Subject: Rezoning Petition Review

Rezoning Petition #: 22-052

Location of Property: Approximately 1.9 acres located on the north side of Tuckaseegee Rd, west of Toddville Rd and north of I-85

SHEET NO.
RZ-1

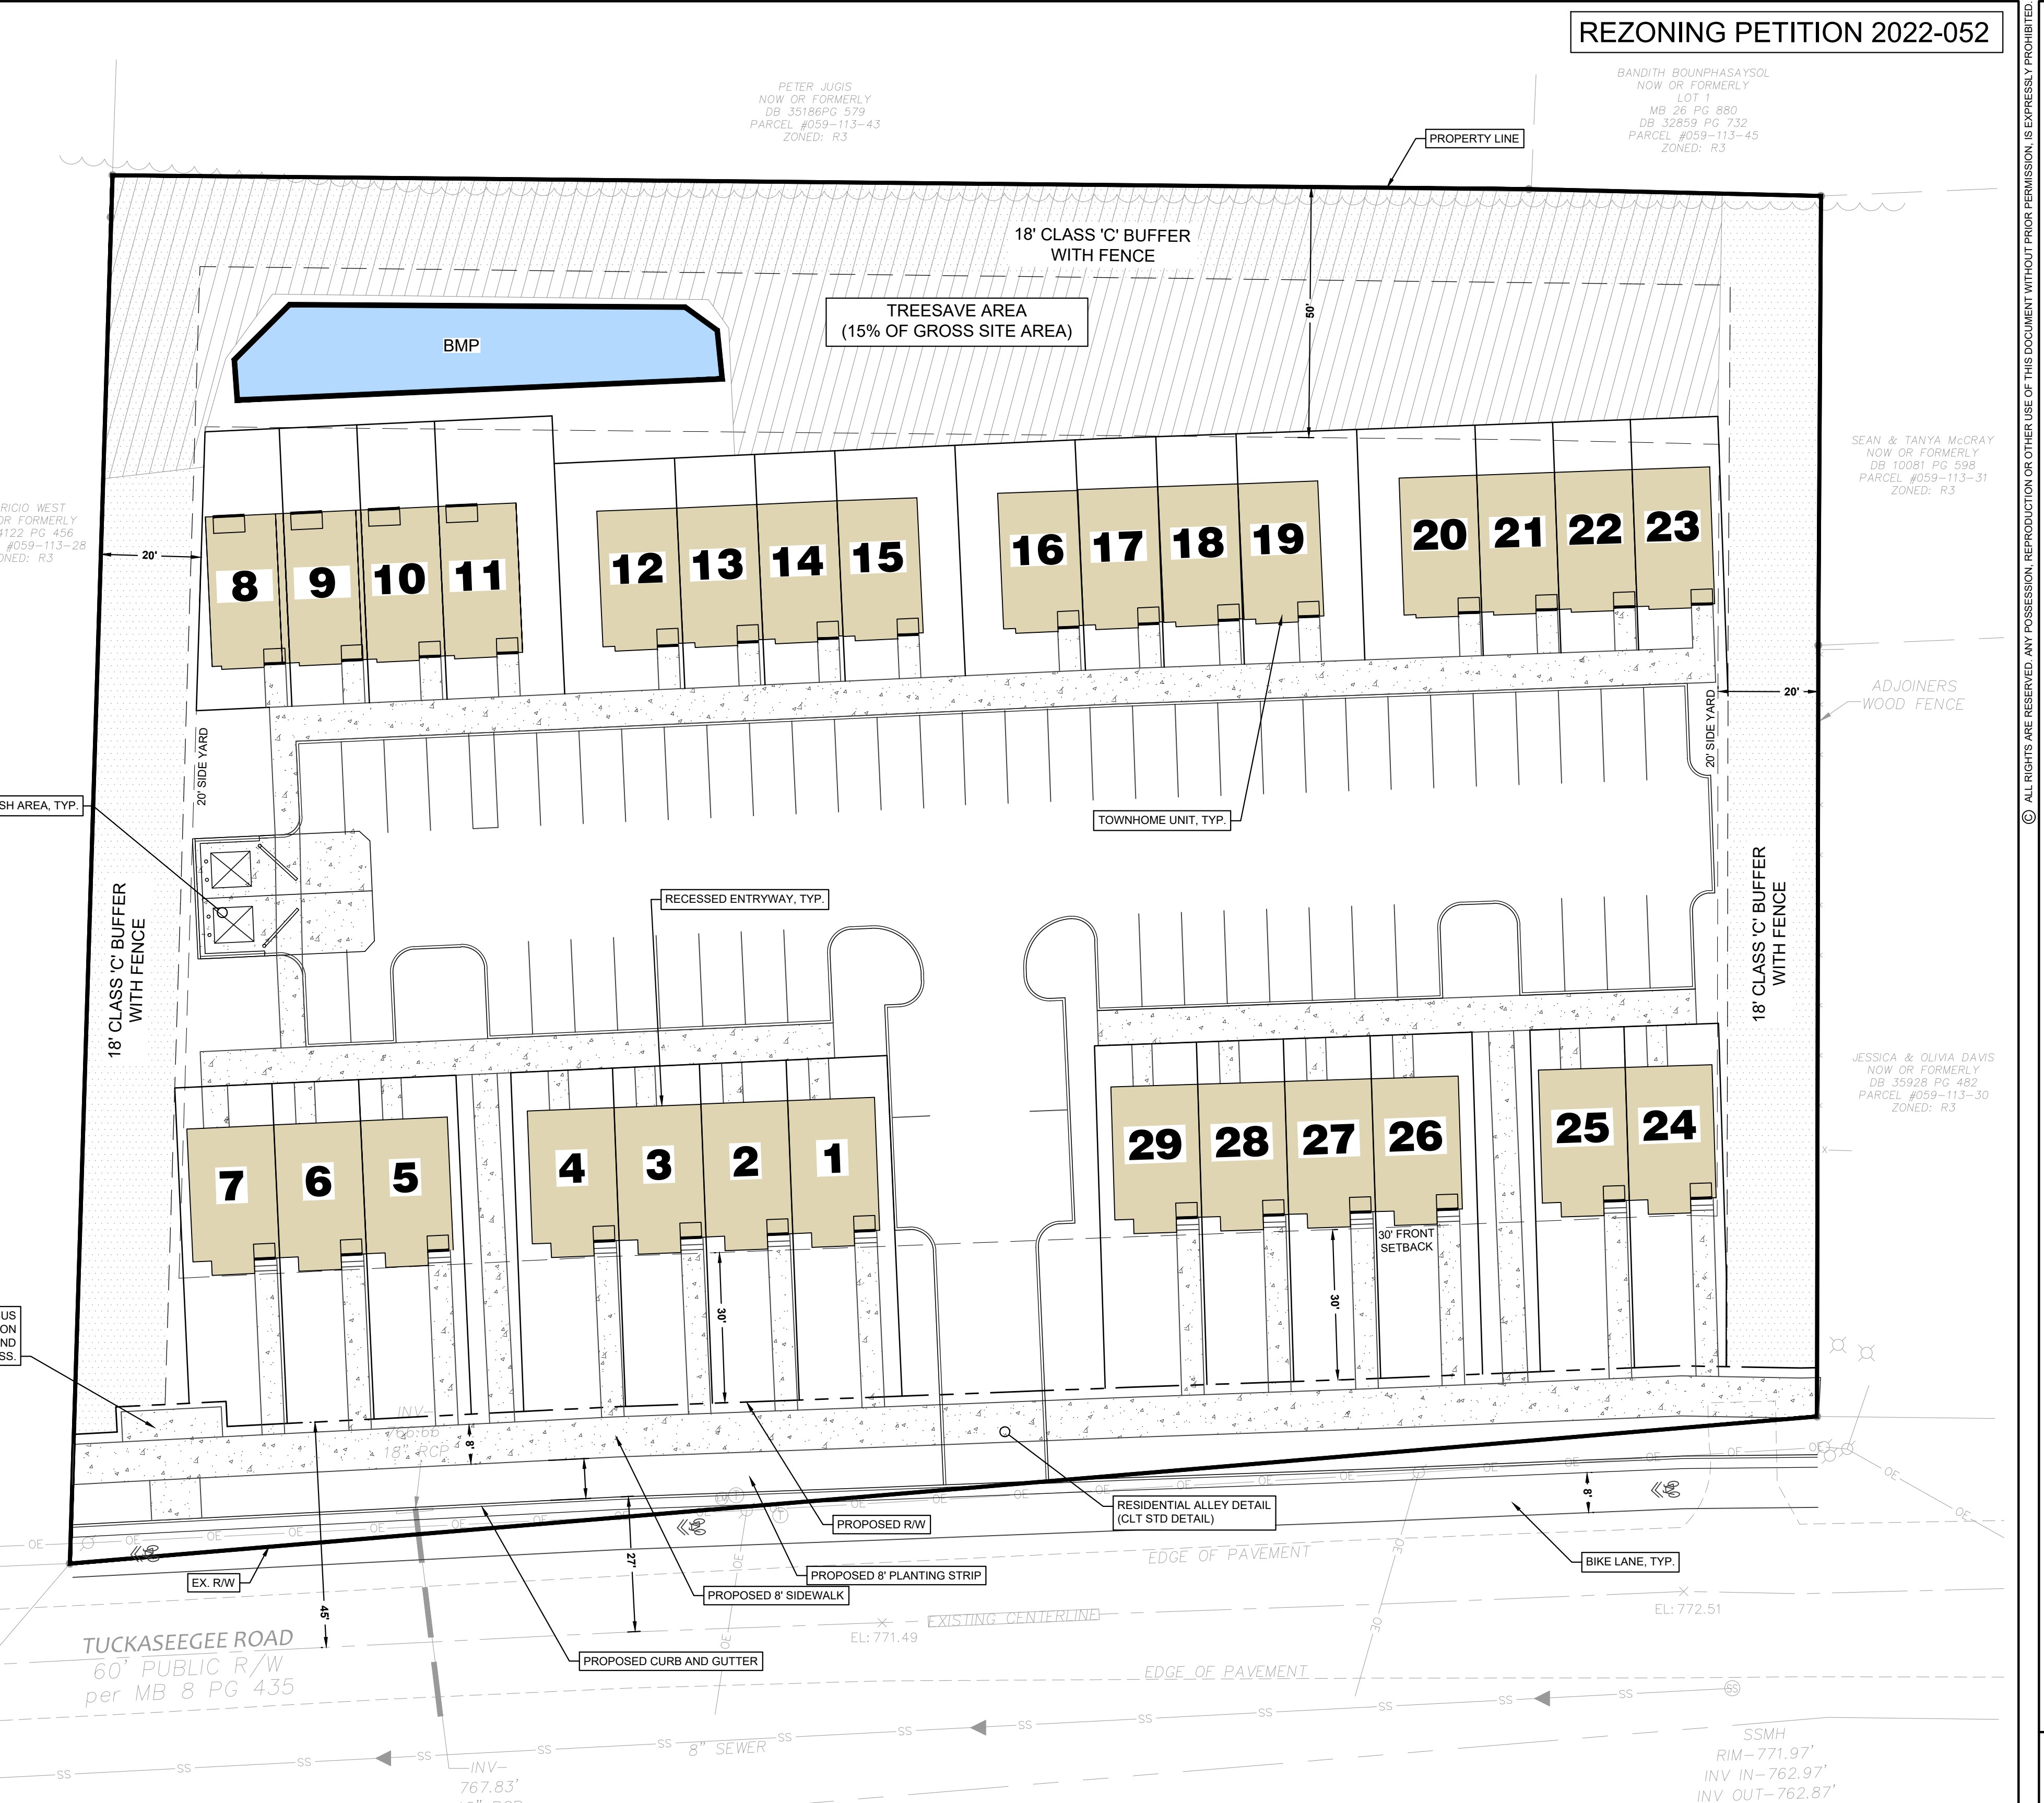
The proposed rezoning plan sheet indicates a proposed location for storm water management. Please include the following notes on the plan sheet under "Environmental Features": *The location, size, and type of storm water management systems depicted on the Rezoning Plan are subject to review and approval as part of the full development plan submittal and are not implicitly approved with this rezoning. Adjustments may be necessary in order to accommodate actual storm water treatment requirements and natural site discharge points.*

This property drains to Paw Creek, which is an impaired/degraded stream, and may contribute to downstream flooding. This project has the opportunity to mitigate future impacts to this stream, therefore, Storm Water recommends placing the following notes on the plan:

For defined watersheds greater than 12% built-upon area (BUA), construct water quality stormwater control measures (SCMs) designed for the runoff generated from the first 1-inch of rainfall for all new and redeveloped BUA associated with the project. SCMs must be designed and constructed in accordance with the Charlotte-Mecklenburg BMP Design Manual.

For defined watersheds greater than 12% built-upon area, control the entire volume for the 1-year, 24-hour storm for all new and redeveloped BUA associated with the project. Runoff volume drawdown time shall be in accordance with the Charlotte-Mecklenburg BMP Design Manual.

For residential projects with greater than 12% BUA, control the peak to not exceed the predevelopment runoff rates for the 10-year and 25-year, 6-hour storms or perform a downstream analysis to determine whether peak control is needed, and if so, for what level of storm frequency.
